Rezoning Petition Review

Date of Review: May 20, 2020

Rezoning Petition #: 20-68

Location of Property: Approximately 8.5 acres located along the east and west side of Hedgemore Rd, south of Woodlawn Rd and west of Selwyn Ave.

SCHEMATIC SITE PLAN
PETITION # 2020-068
FOR
HEDGEMORE - MONTFORD PARK
CHARLOTTE, NORTH CAROLINA 28209

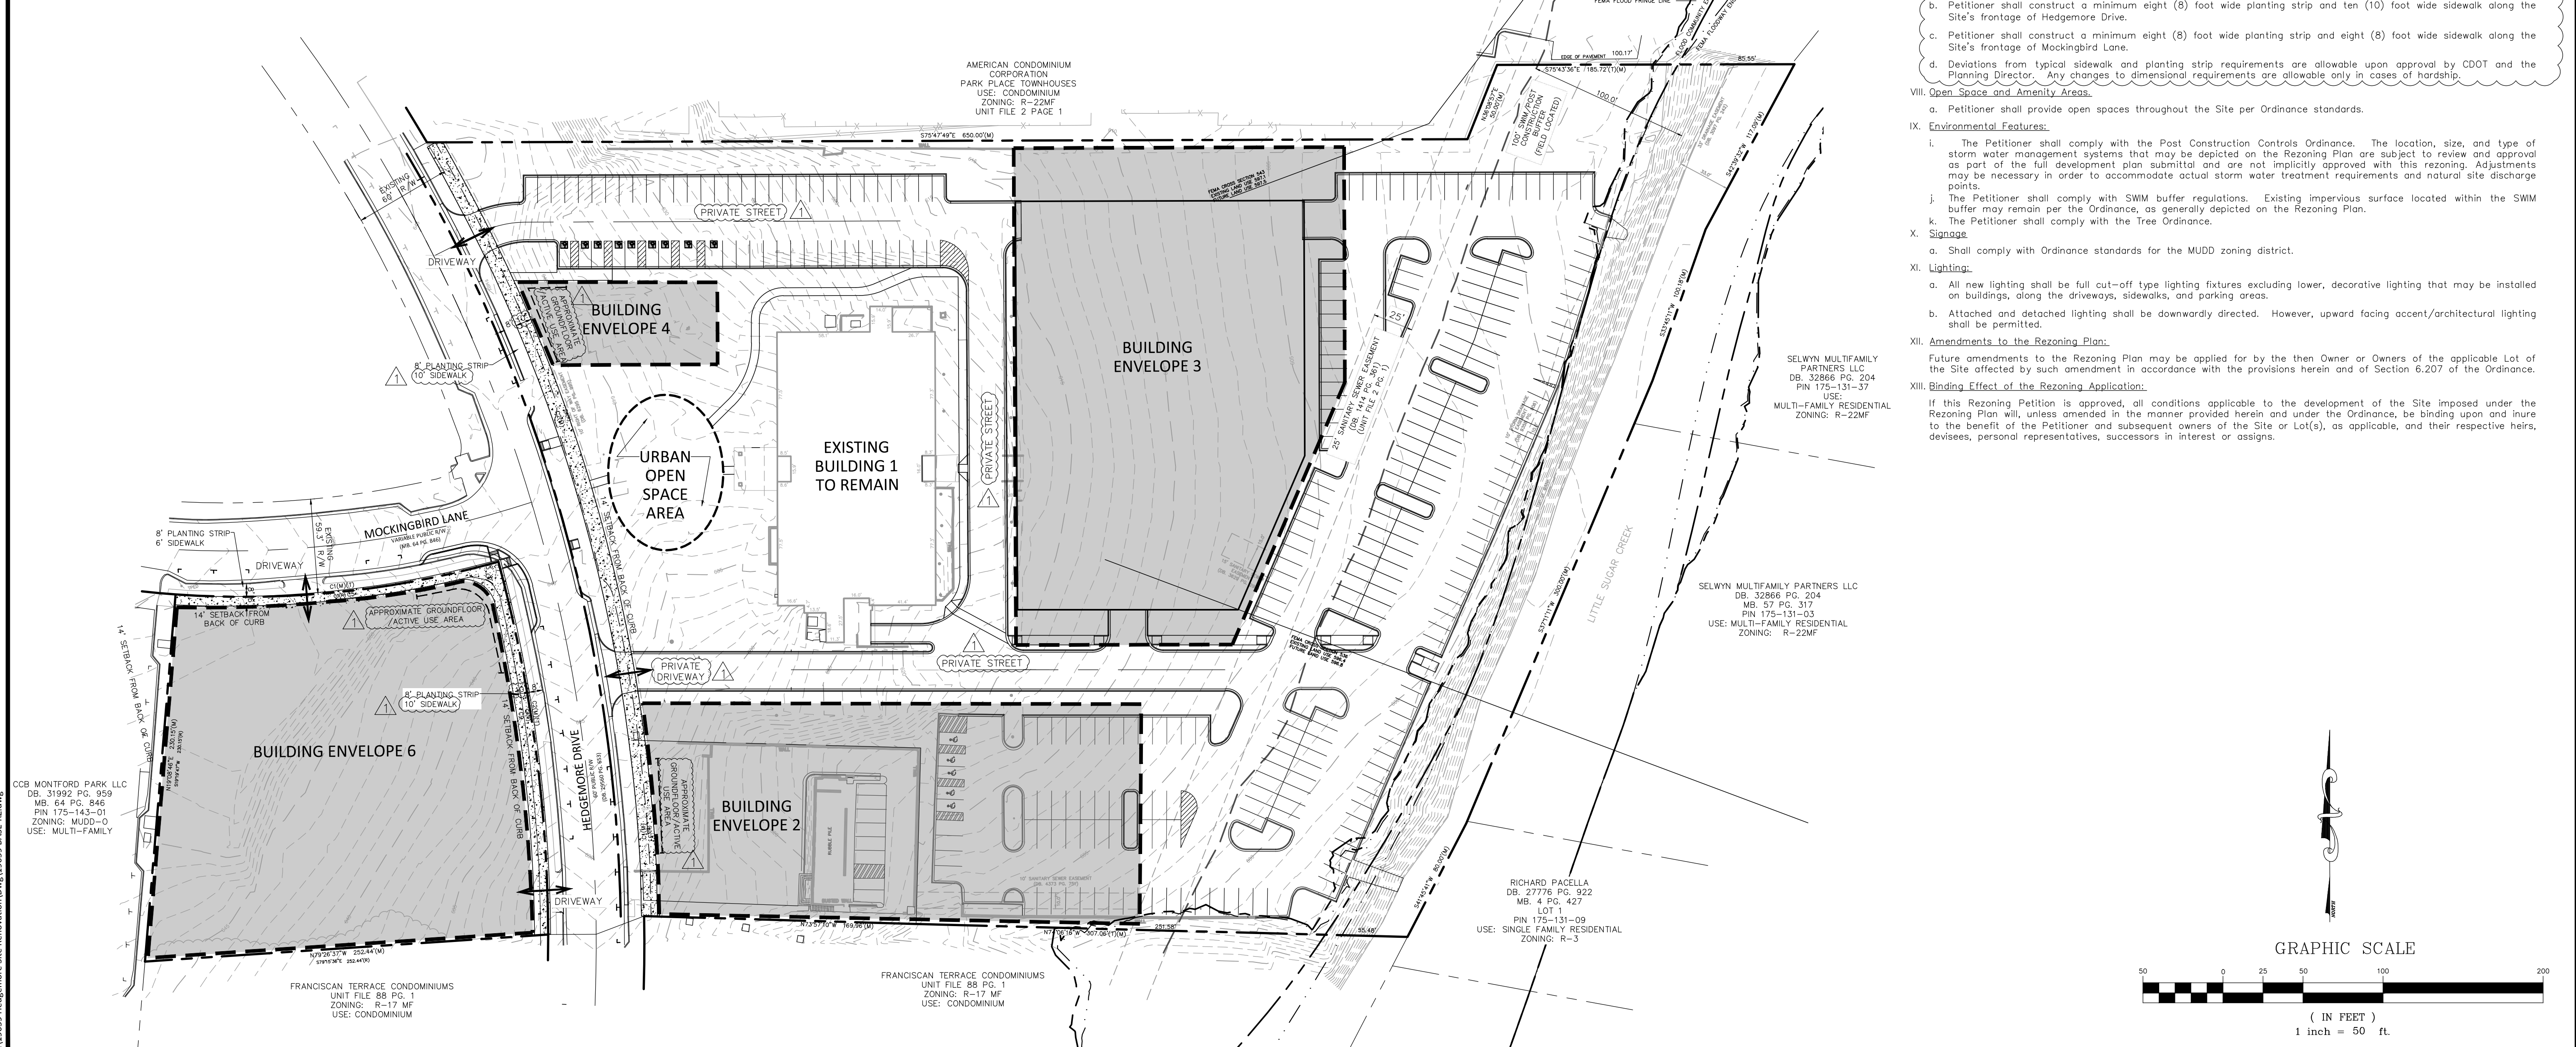
Please remove note "b" under *Environmental Features* in its entirety and replace with the following note: *Development within the SWIM/PCSO Buffer shall be coordinated with and subject to approval by Charlotte-Mecklenburg Storm Water Services and mitigated if required by City ordinance. Please note Stream Delineation Reports are subject to review and approval by Charlotte Storm Water Services.*
